### **Rocky Top, VA-18-250**

**Please accept the following comment from El Paso County Public Health for variance request referenced above:**

# PLOT PLAN

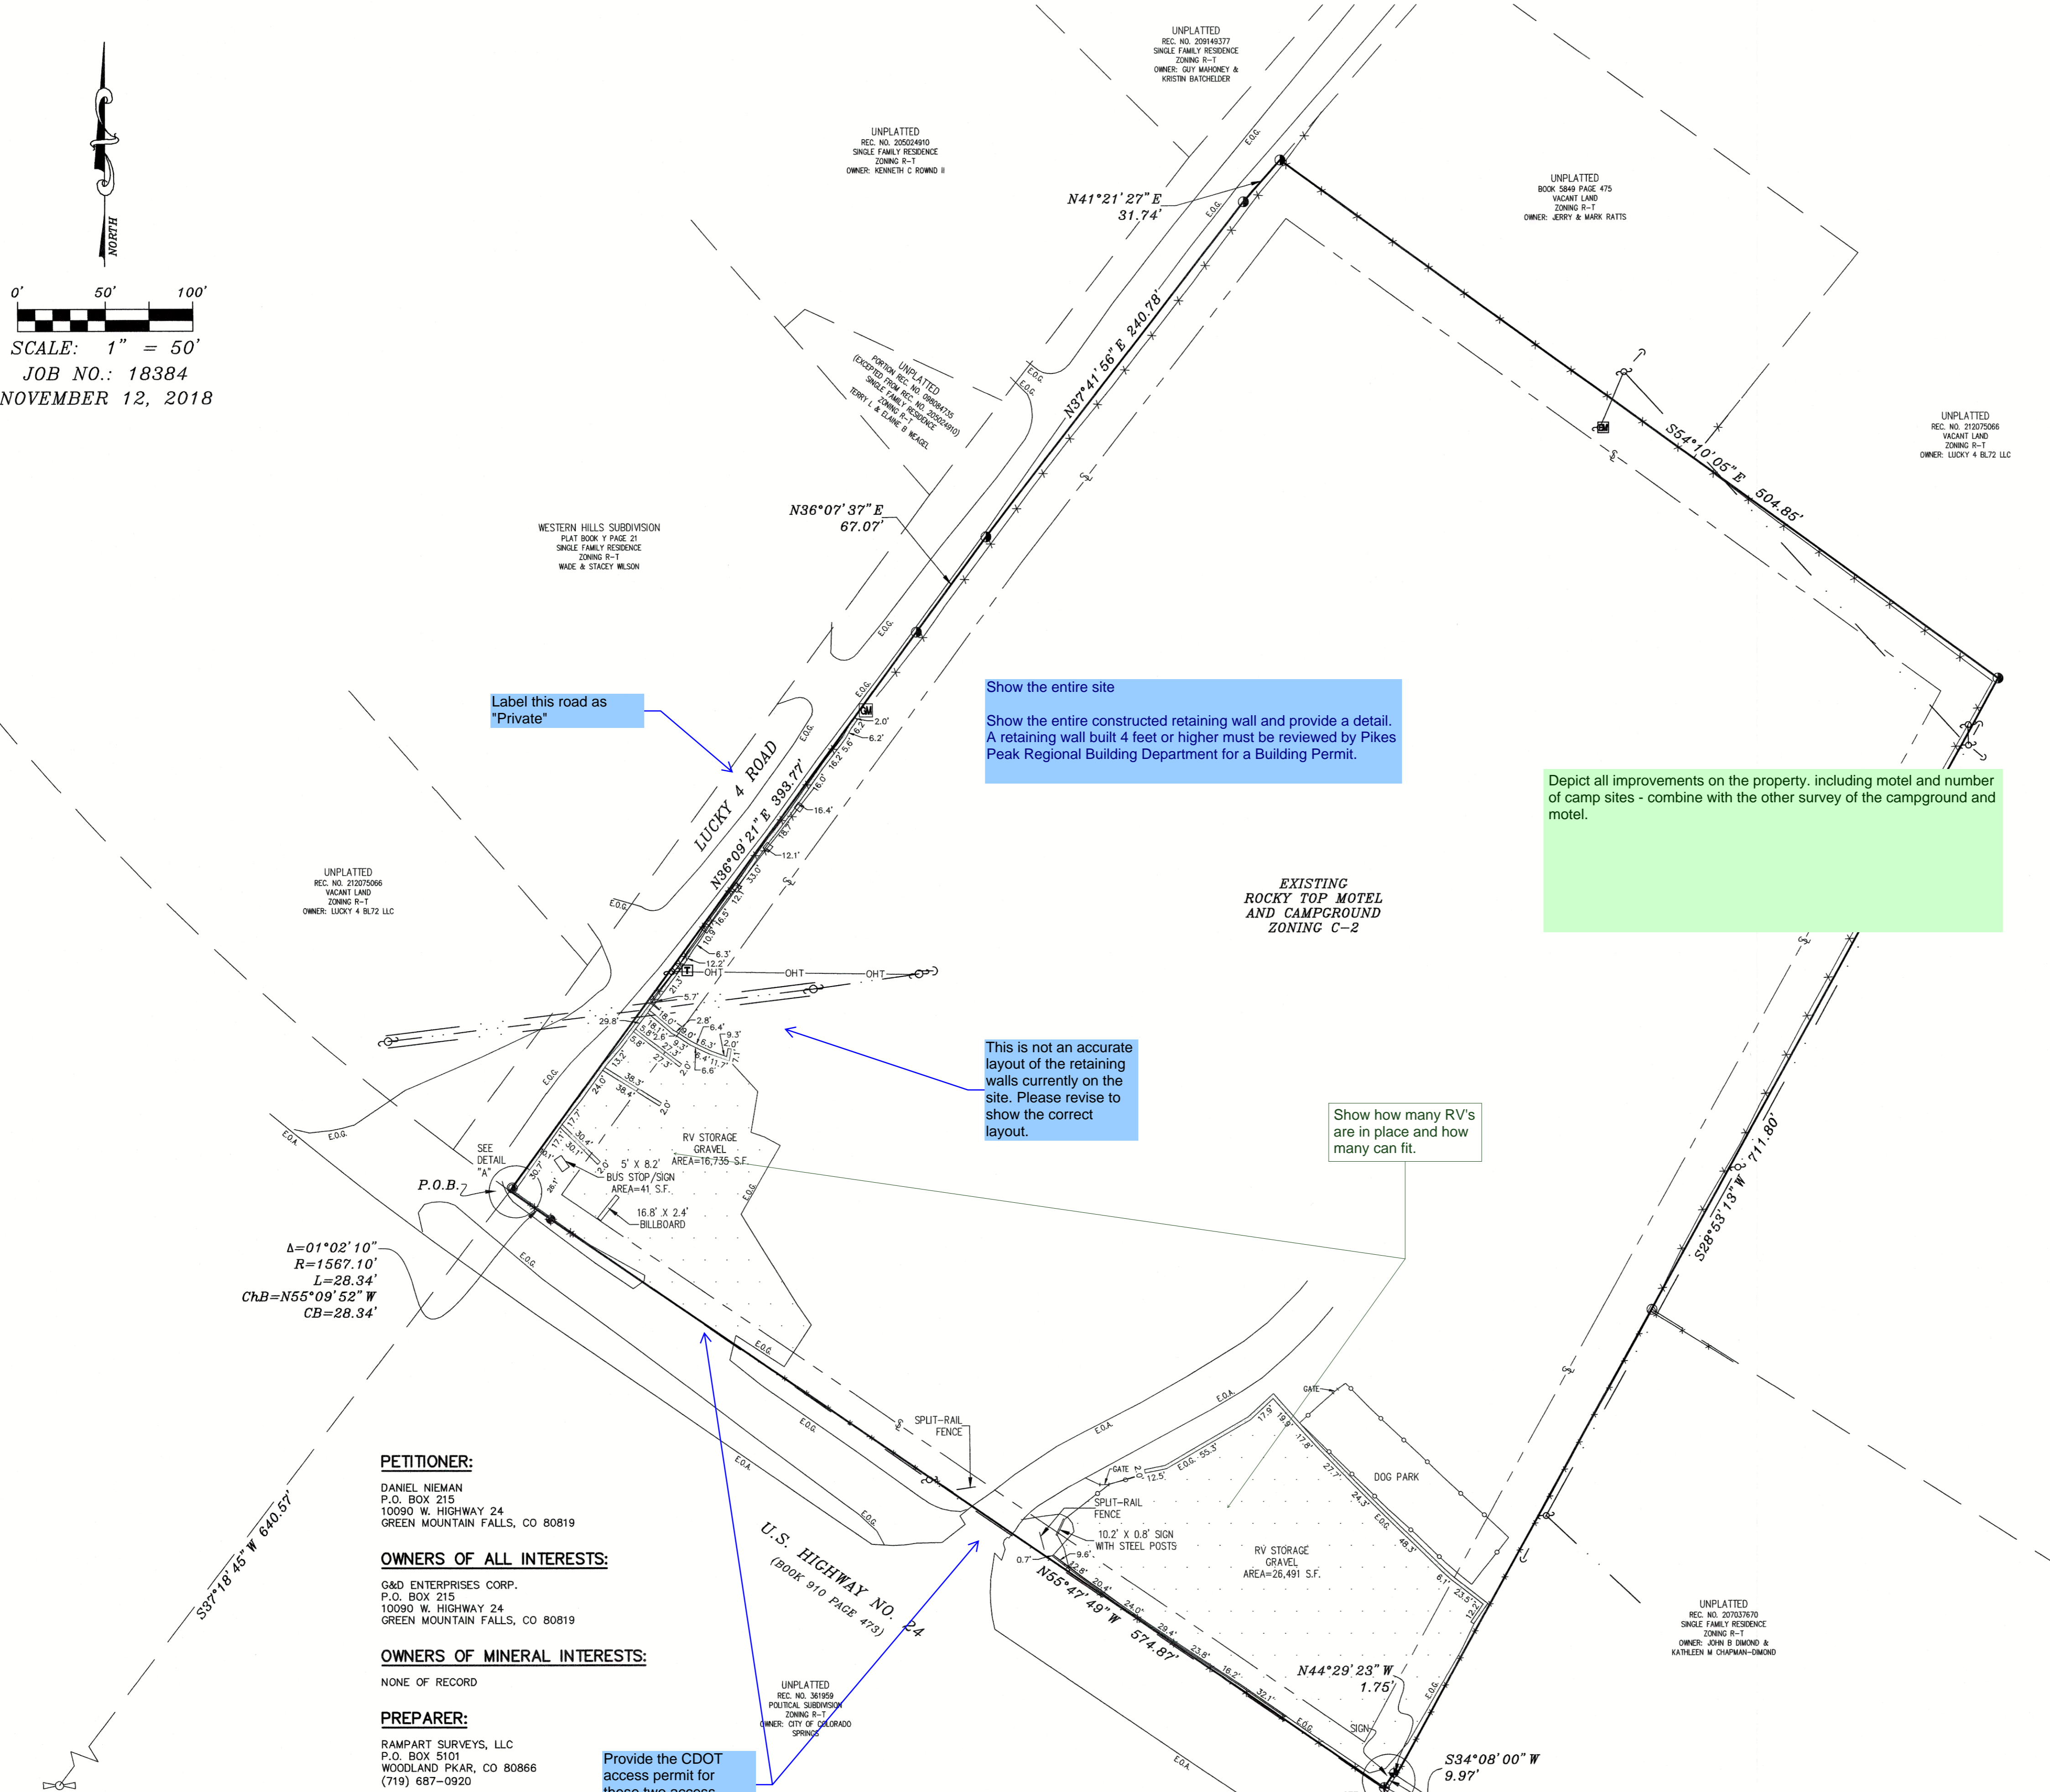
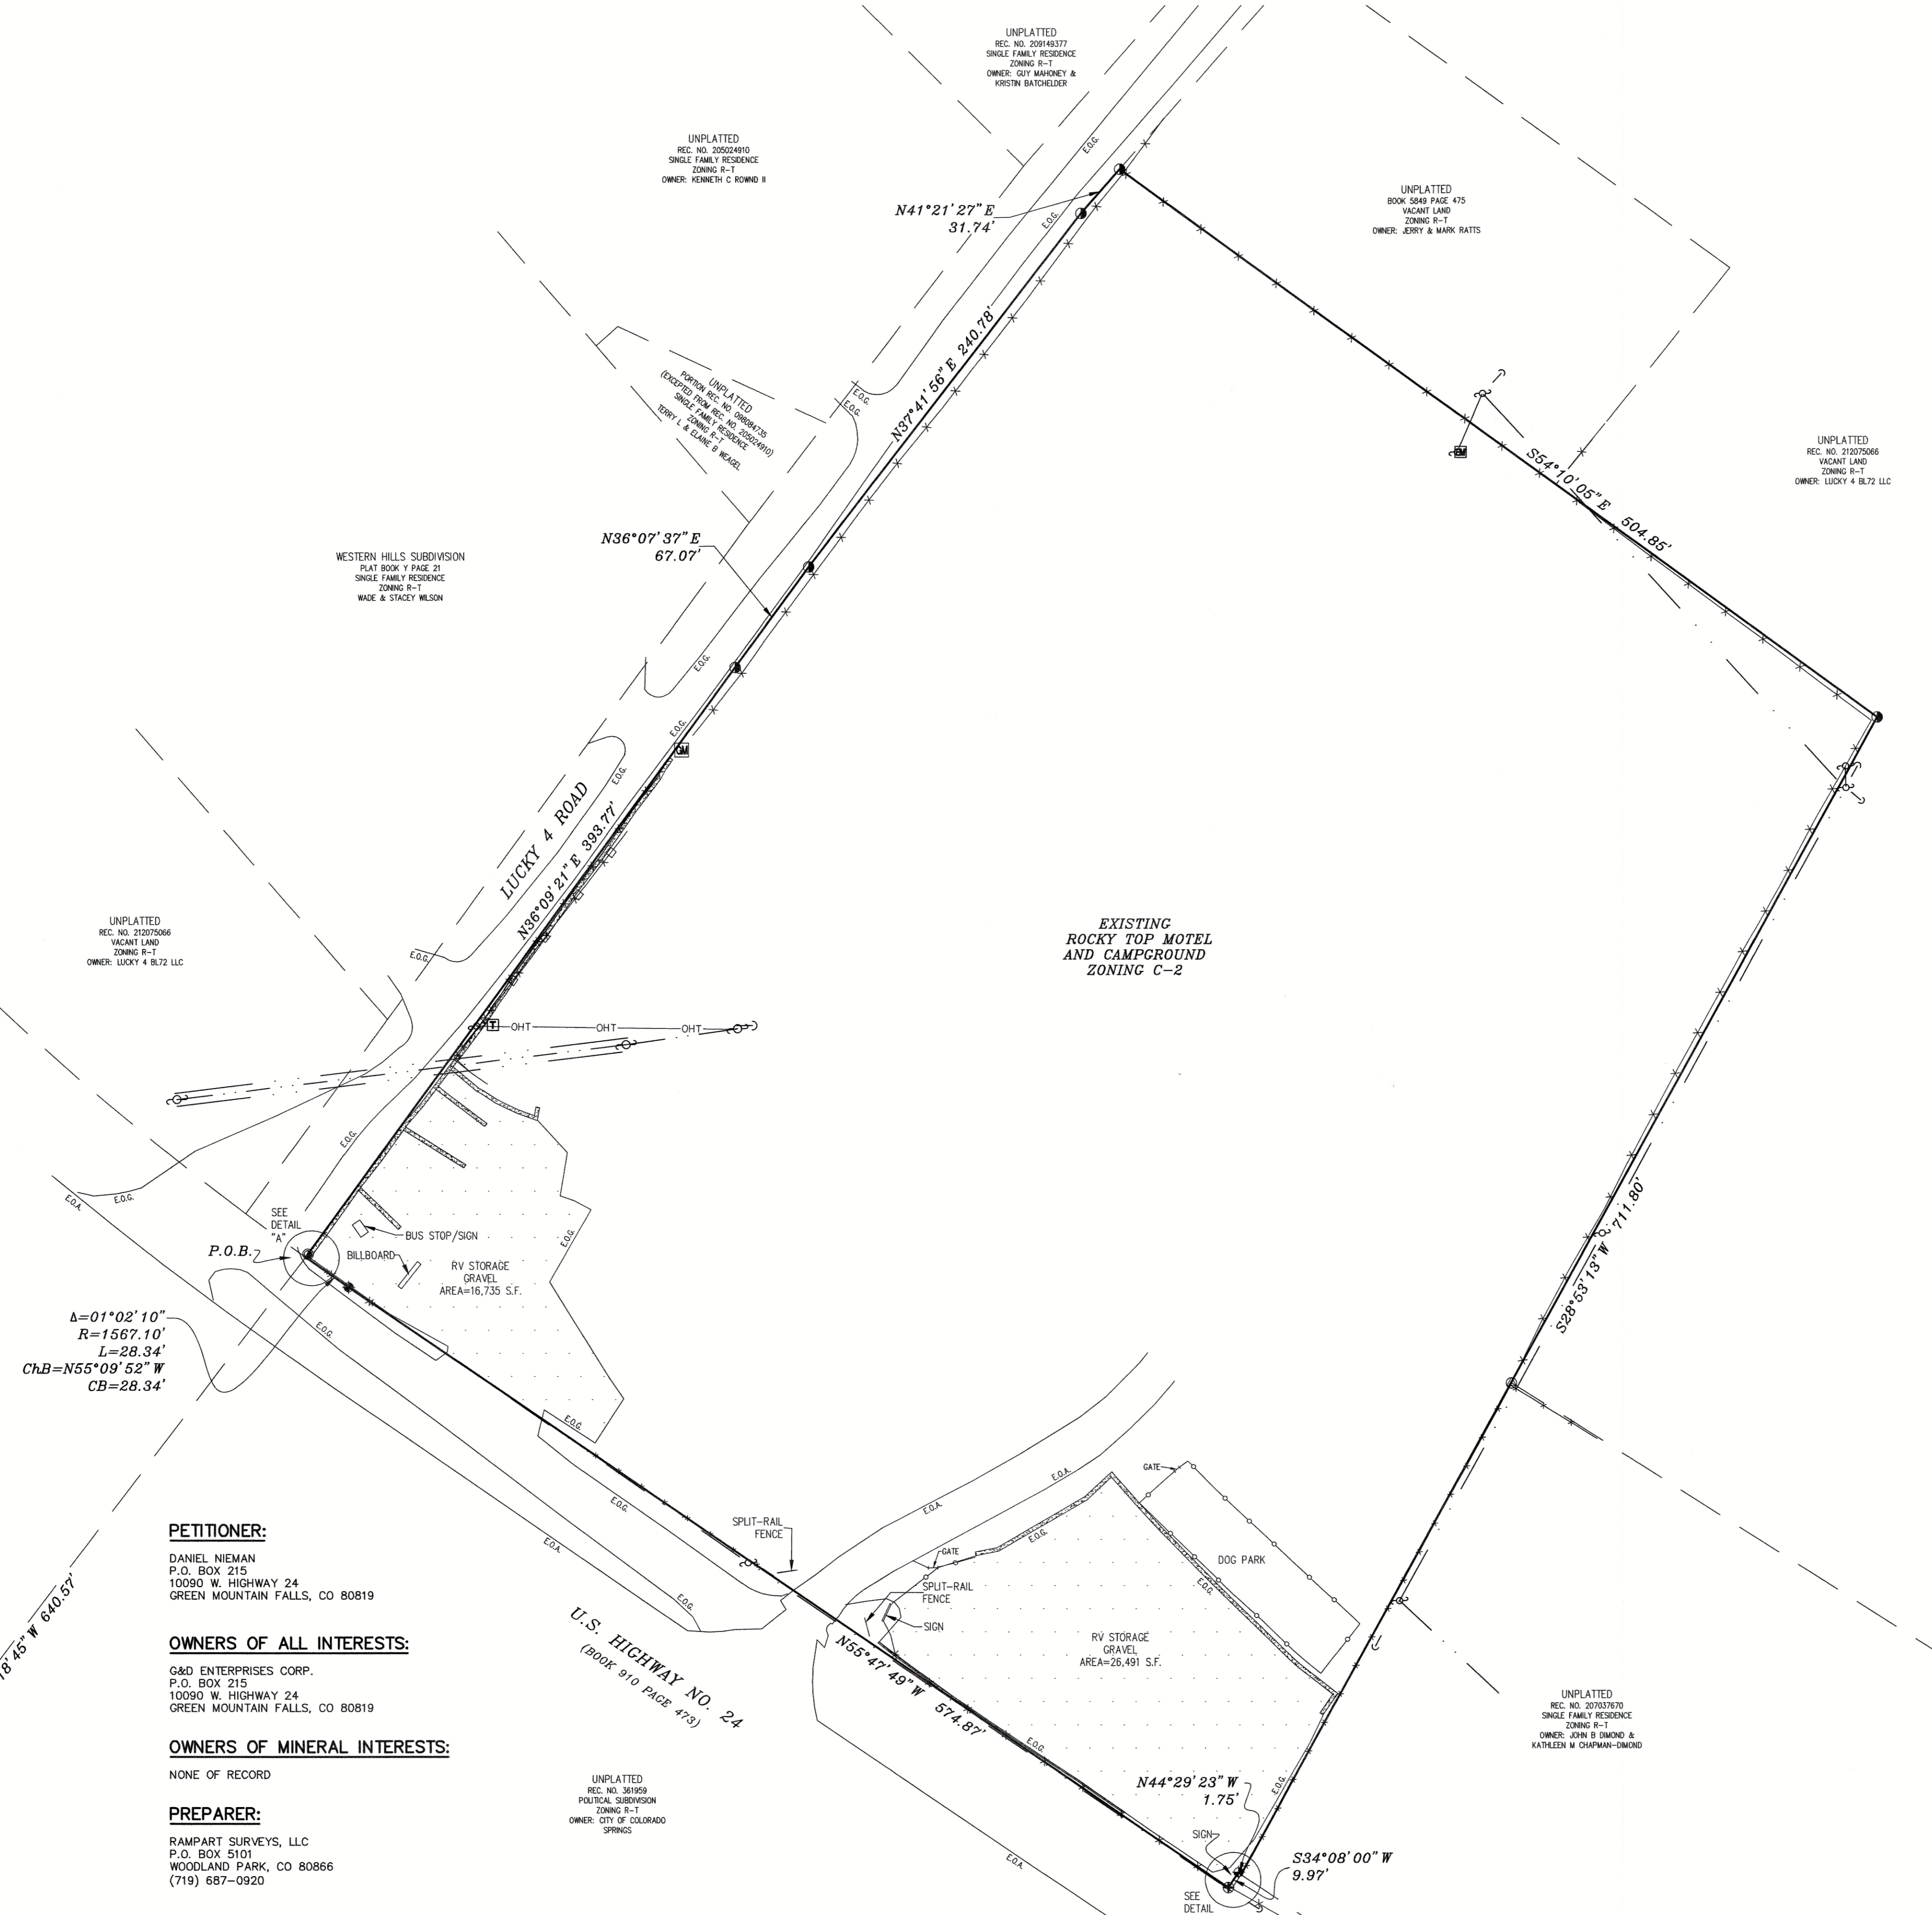
- **The closest onsite wastewater treatment system (OWTS), soil treatment area (STA) to the proposed RV storage area must be located and protected from all vehicular traffic both during and after all site work associated with the site work.**
- **Earthmoving activity in excess of one acre, but less than twenty-five acres, requires a local Construction Activity Permit from El Paso County Public Health. Go to <https://www.elpasocountyhealth.org/service/air-quality/construction-activity-application> for more information.**
